**Recommendation Report for Listed Building Consent for Alterations, Extension or Demolition of a
Listed Building**

REF NO: AL/11/22/L

LOCATION: Boundary wall to Nyton House
Nyton Road
Westergate
PO20 3UL

PROPOSAL: Listed building consent for the part demolition of boundary wall to form new access to existing site.

06| Proposed Site Plan

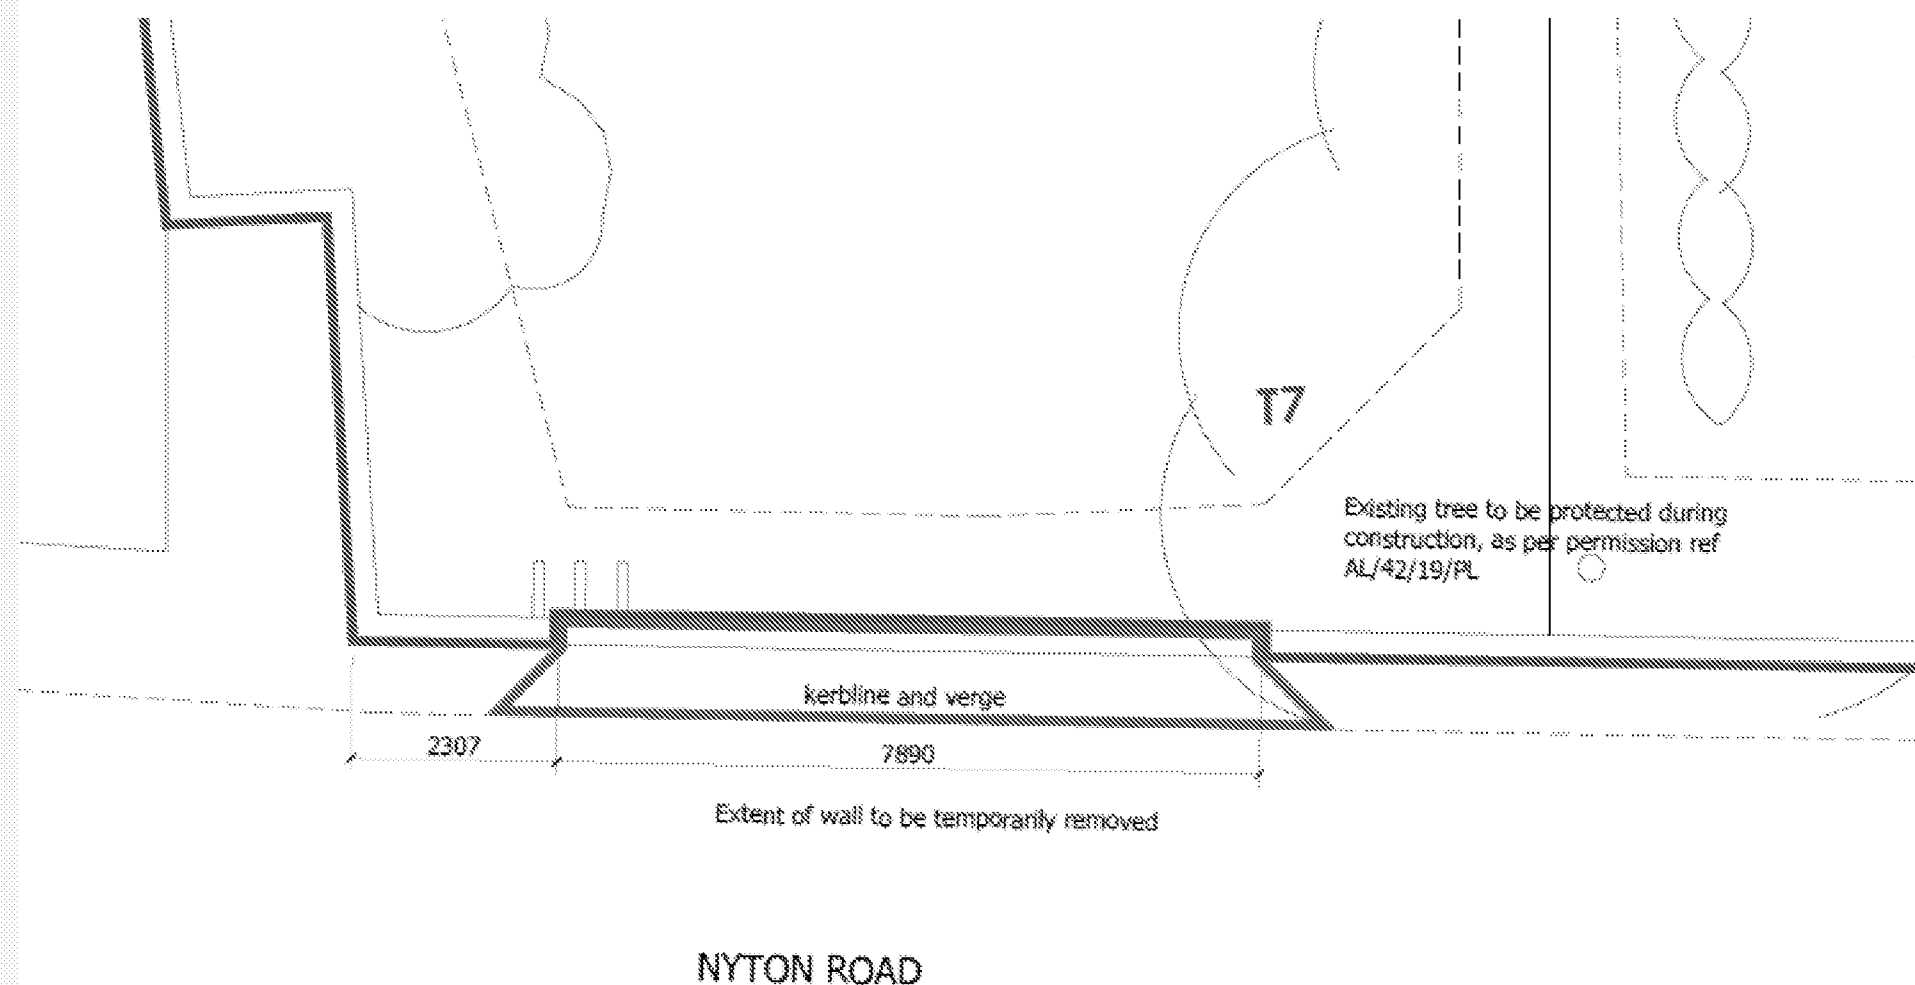
The application relates to the part demolition of the boundary wall to form a new access. This implies that the section of wall is to be removed on a permanent basis. However, a review of the Design and Access Statement shows that the wall is to be removed temporarily and reconstructed on completion of construction works. This seems to imply that the section of walling will be re-built when the new development within the site has taken place. An area of approx. 8m width would be removed as part of this proposal which the agent identifies as containing numerous examples of cracking, dilapidation and historic damage to this section of the wall. The heritage statement identifies that the works are deemed to be a necessary alteration in order to facilitate construction works on the site of Nyton House. On its own, the loss of the boundary walling for construction works elsewhere is not an acceptable argument for the loss of historic fabric.

It would help to have a more detailed record of the walling so that the reconstruction could be carefully assessed and managed. All existing flint and bricks should be carefully cleaned and retained on site so that it can be re-used as part of the rebuilt wall. I would want to make sure that the quality of the rebuild is high and reflects the existing. A sample panel would be required, along with details of the proposed mortar mix - this could be based on an analysis of an existing sample.

It is not clear how the exposed sections of the walling will be treated for the duration of the works, nor how long it is anticipated for the section of walling to be missing. This information should be provided.

- 2 A sample panel for the infilling of the wall along with details of the proposed mortar mix shall be submitted and approved by the Local Planning Authority prior to reconstruction of the wall. The sample panel approved by the Local Planning Authority shall be used in the construction of the development. The could be based on an analysis of an existing sample.

- 3 All of the existing flint and bricks should be carefully cleaned and retained and must be re-used as part of the rebuilt wall.

- 4 Within 3 months of the works which require the demolition of the wall being completed, or two years from the date of this permission which ever is earlier, the wall shall have been rebuilt in accordance with conditions 2 and 3 above.
